From: [REDACTED]
Sent: 08 December 2023 17:30
To: MU1
Subject: 2021/1089 & 2021/1090

Thank you for consulting me regarding the above applications. Comments below set out where amendment or clarification is required. A summary is provided at the end of these comments, which should hopefully assist in your understanding of potential biodiversity impacts on site and mitigation/compensation proposed.

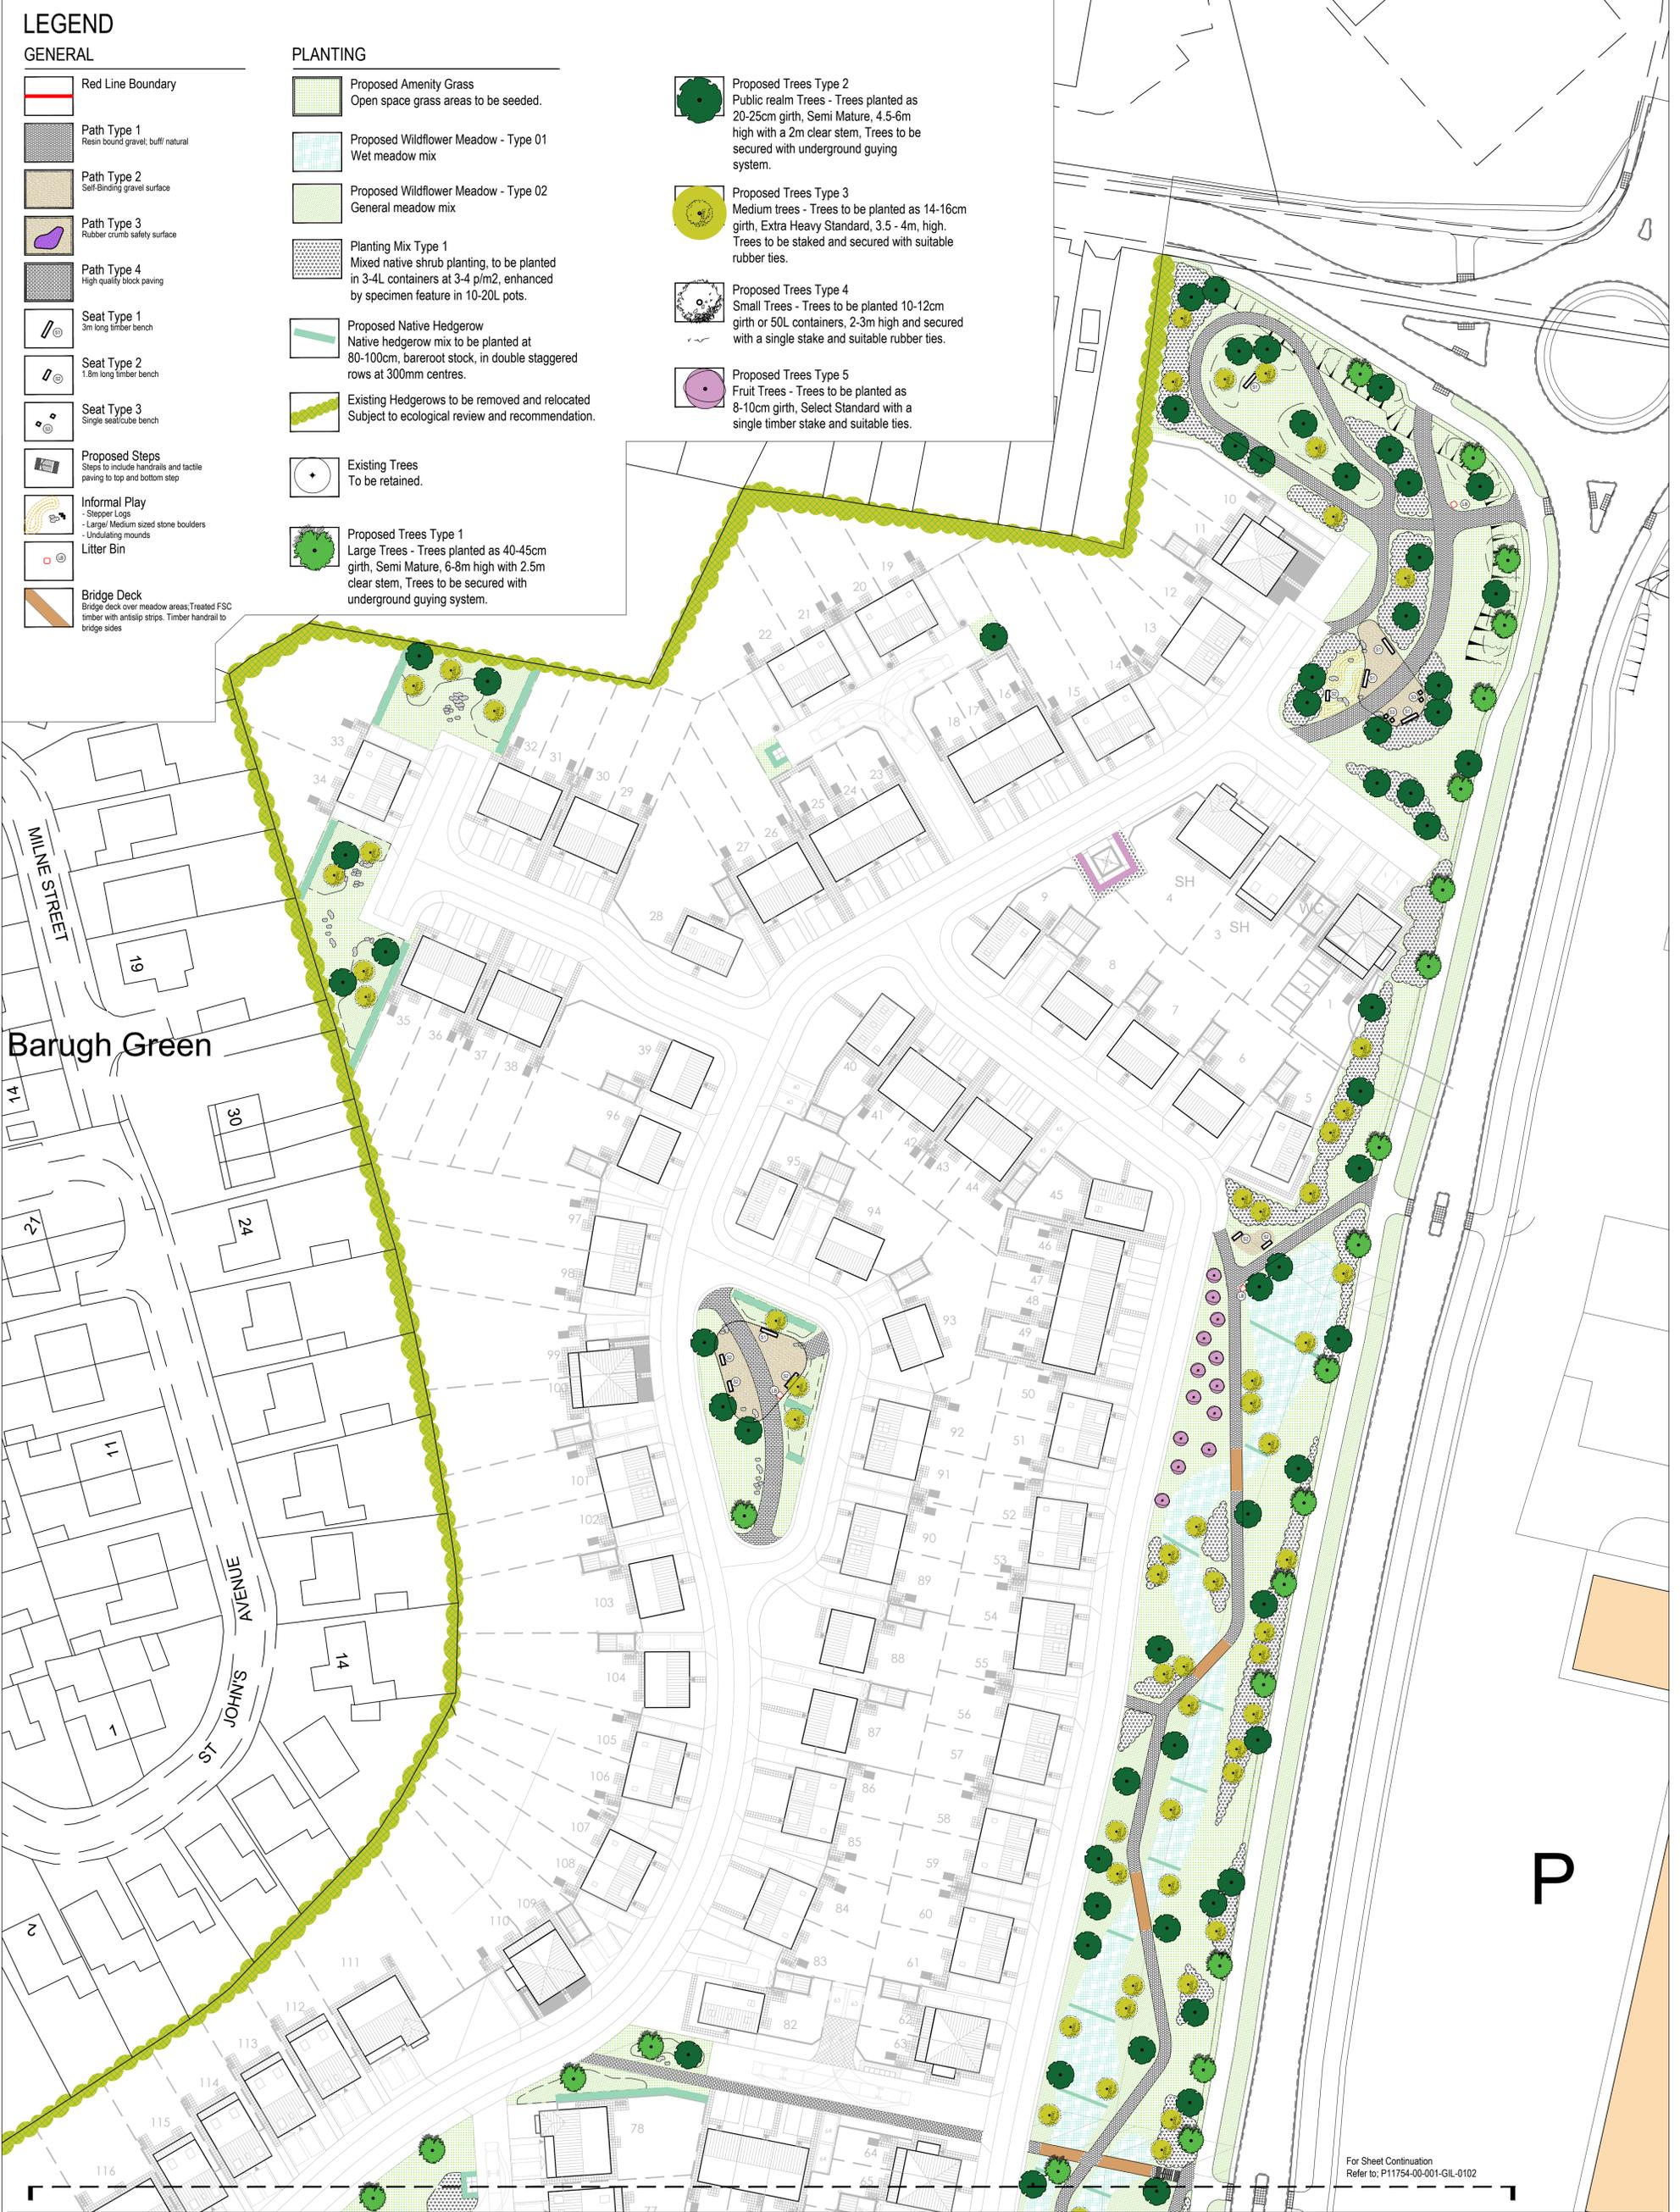
- The strategic landscaping proposed on site is considered to provide significant on-site net gains. We would therefore seek to secure this by a Section 106 agreement, with this given as an option to secure on-site gains within the government's Biodiversity Net Gain (BNG) guidance. A management and monitoring plan of habitats proposed would be a requirement of the Section 106, with this setting out management and monitoring over 30 years from the implementation of each phase of the landscaping. Monitoring of the landscaping would be undertaken periodically over the 30 years, with subsequent monitoring reports submitted to the LPA. We will charge a fee to review monitoring reports over this period, which will be set out within the Section 106 agreement. It is unclear who will be responsible for the implementation of the strategic landscaping; this information should be provided.

- Residential and commercial phases of development can be subject to a planning condition at reserved matters stage to provide an updated metric to demonstrate that the overall site is on track to achieving at least a 10% net gain. This can be provided alongside a management and monitoring plan covering the thirty-year period from the implementation of public green space on site. This will deal with flags regarding time to target condition within the metric for smaller areas of woodland proposed in association with phases of residential development, where time to target condition is 30 years.

- It is noted within the landscape masterplan that there are areas of species-rich grassland and traditional wildflower meadow, and both are classed as other neutral grassland of moderate condition in the habitat creation tab of the metric. Is management likely to differ for these two habitat types which might make the proposed habitat type within the metric difficult to achieve?
